**KIRKLEES METROPOLITAN COUNCIL  
INVESTMENT & REGENERATION SERVICE**

**DELEGATED DECISION FOR APPLICATION FOR CERTIFICATE OF  
LAWFUL DEVELOPMENT**

Reference no.: 2026/CL/90565/E

Site: Spen House, Spen Lane, Gomersal, Cleckheaton,  
BD19 4AD

H.M. LAND REGISTRY			TITLE NUMBER	
			WYK 63936	
ORDNANCE SURVEY PLAN REFERENCE	SE 2025 NW SE 2025 SW SE 1925 SE SE 1925 NE	SECTION	Scale 1/1250	
COUNTY	WEST YORKSHIRE	DISTRICT	KIRKLEES	© Crown Copyright 1996

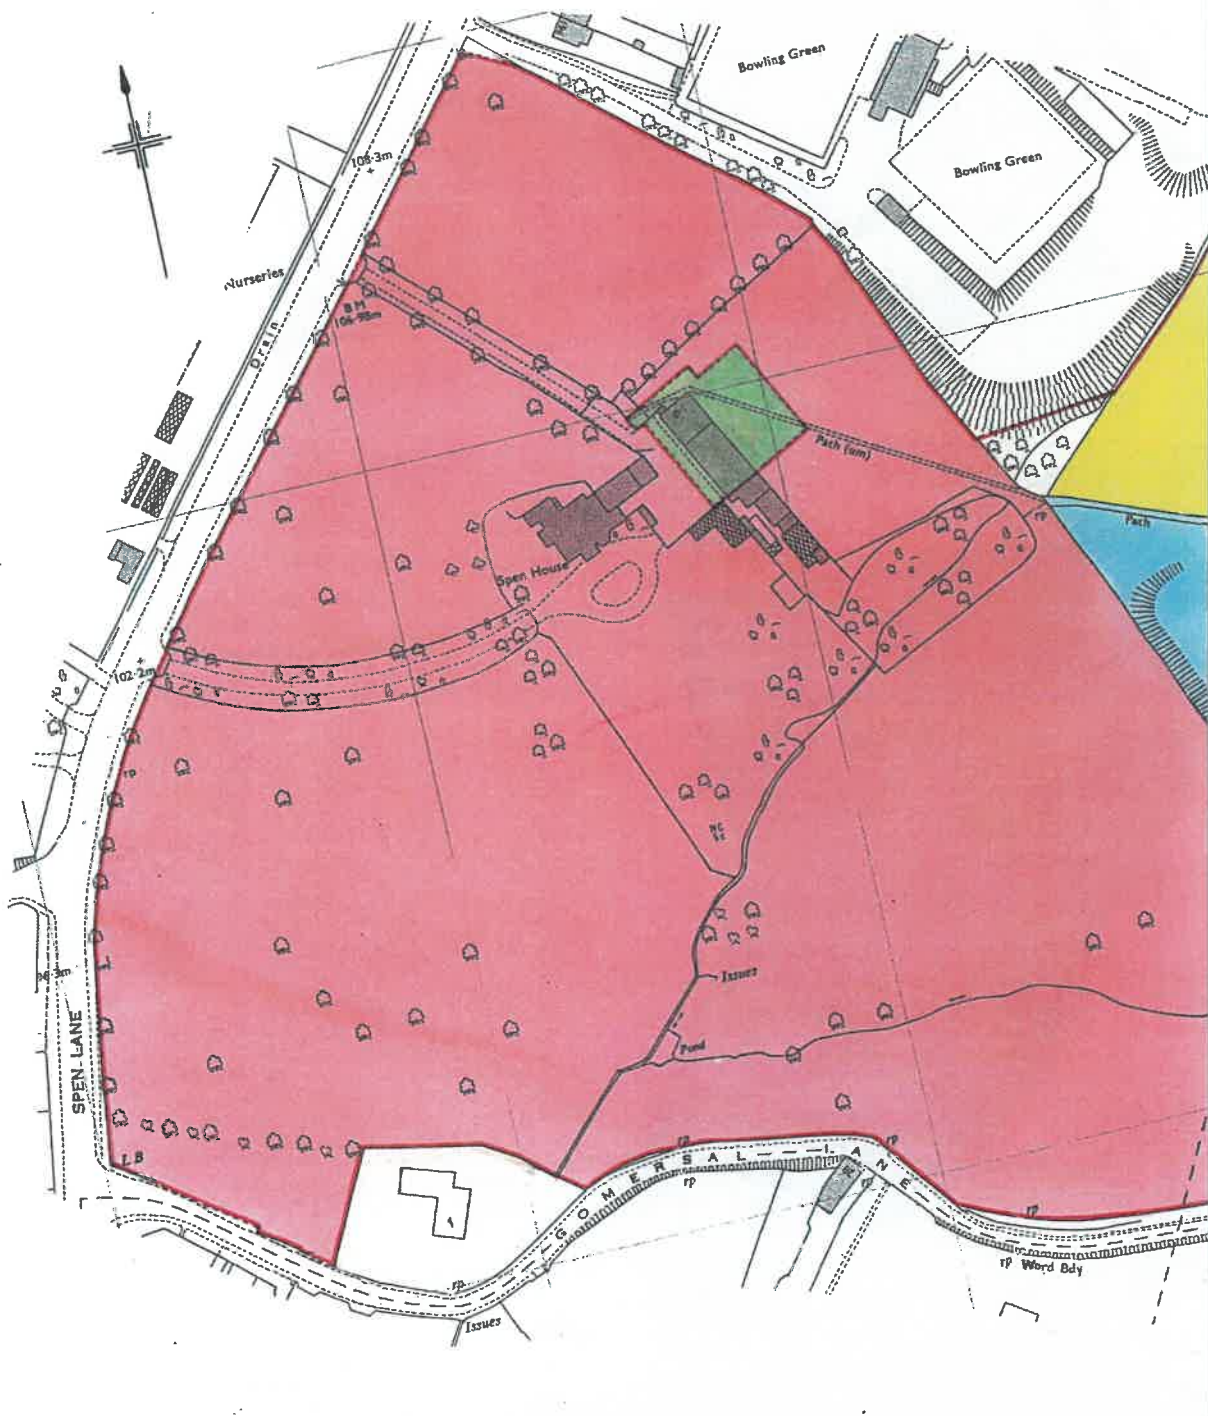
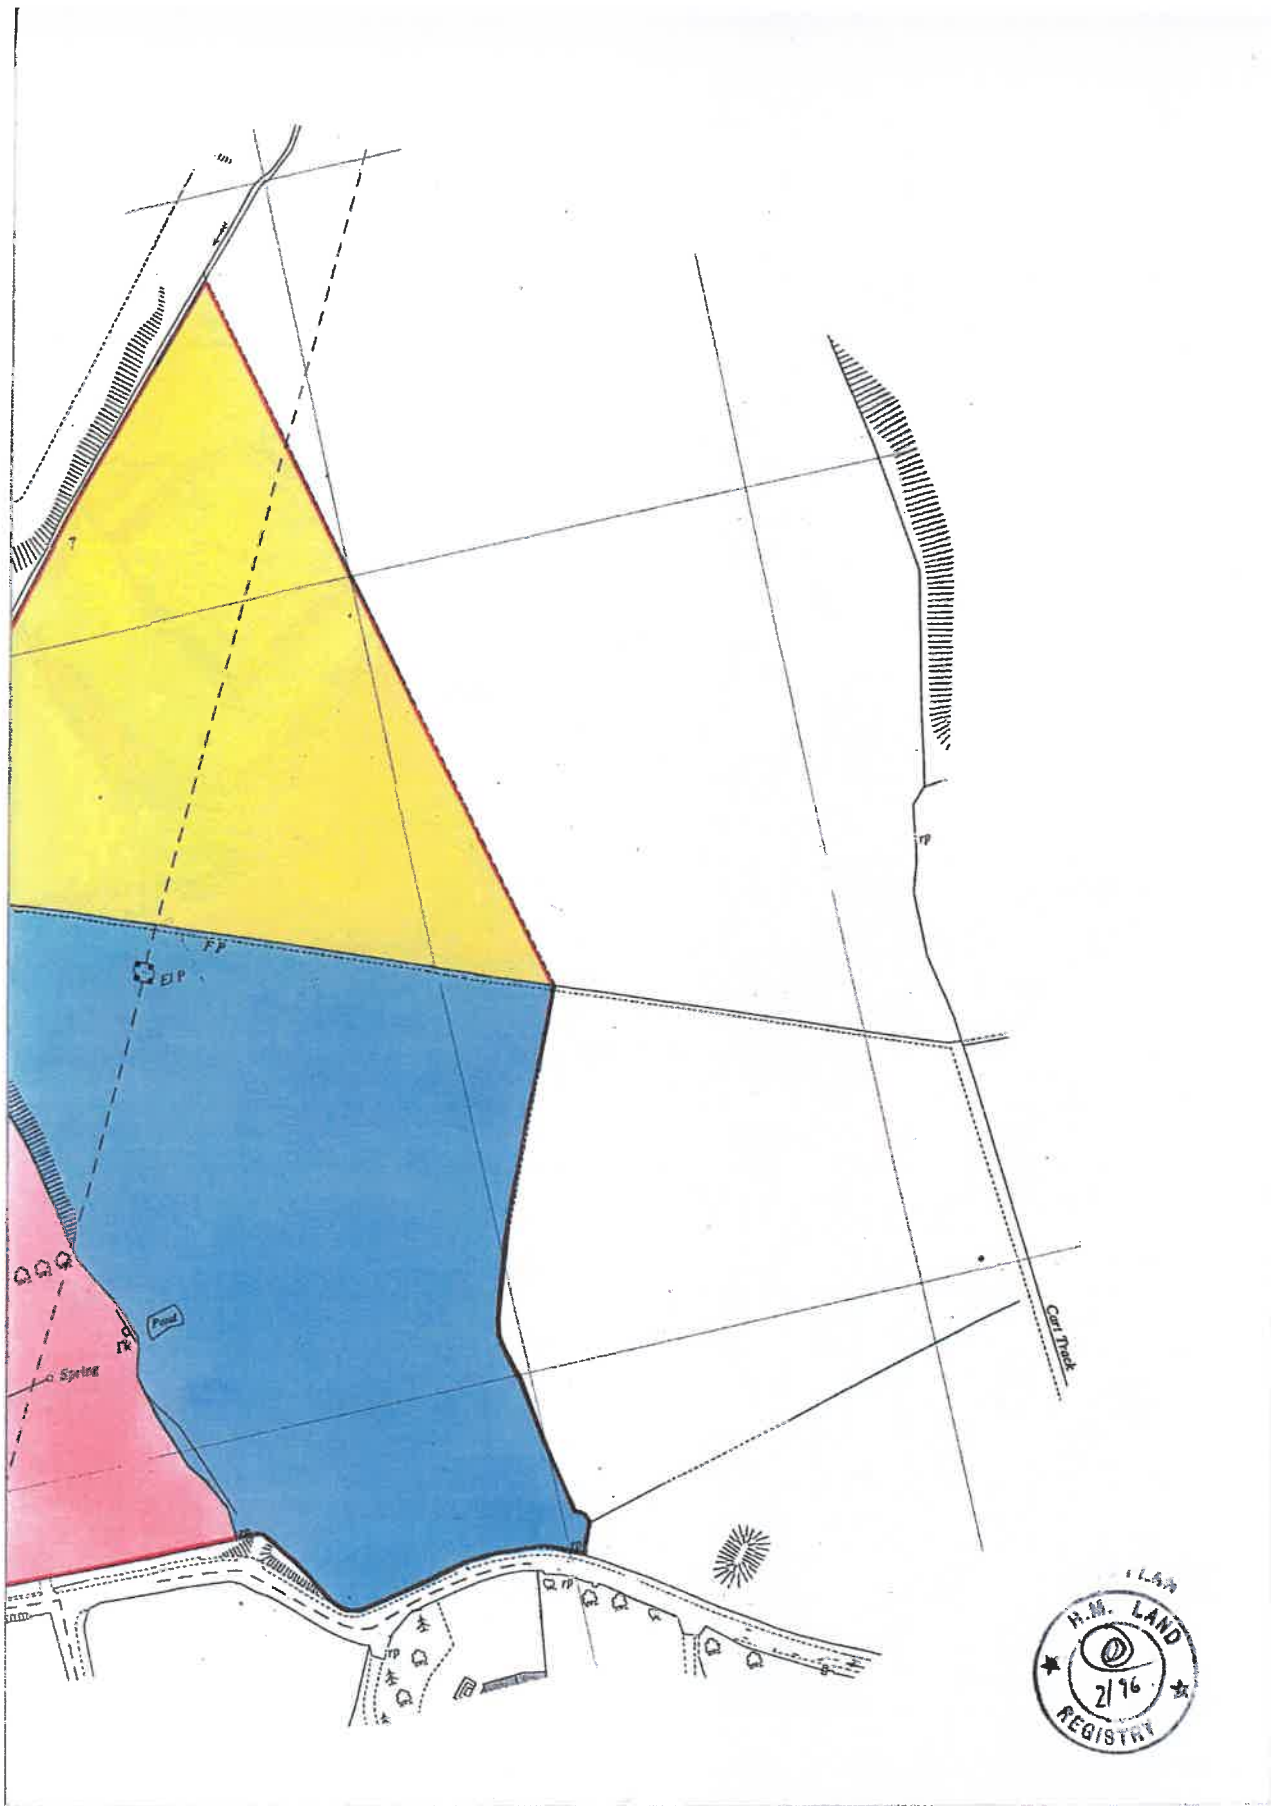
As part of the submission, the application form states that the agricultural holding is more than 5 hectares. However, whilst a 'deed plan ownership' plan has been submitted, this does not demonstrate unambiguously that agriculture within a defined agricultural unit is taking place within the site; nor that the size of building proposed is reasonably required for the storage of hay. Google Earth imagery over the years does not provide any demonstrable evidence to indicate any agricultural activities have been undertaken over any significant period since 2002. Some land to the east of the proposed building has some evidence of grass clipping in 2015 although there is no clear evidence this formed part of any established agricultural unit has includes the land subject to this application. This lack of detail does not clearly demonstrate that the use of all the land within ownership outlined in blue is used for agricultural purposes and there is no clear boundary to the extent of curtilage or garden area for the property. As such, the use of the land for agricultural purposes has not been demonstrated.
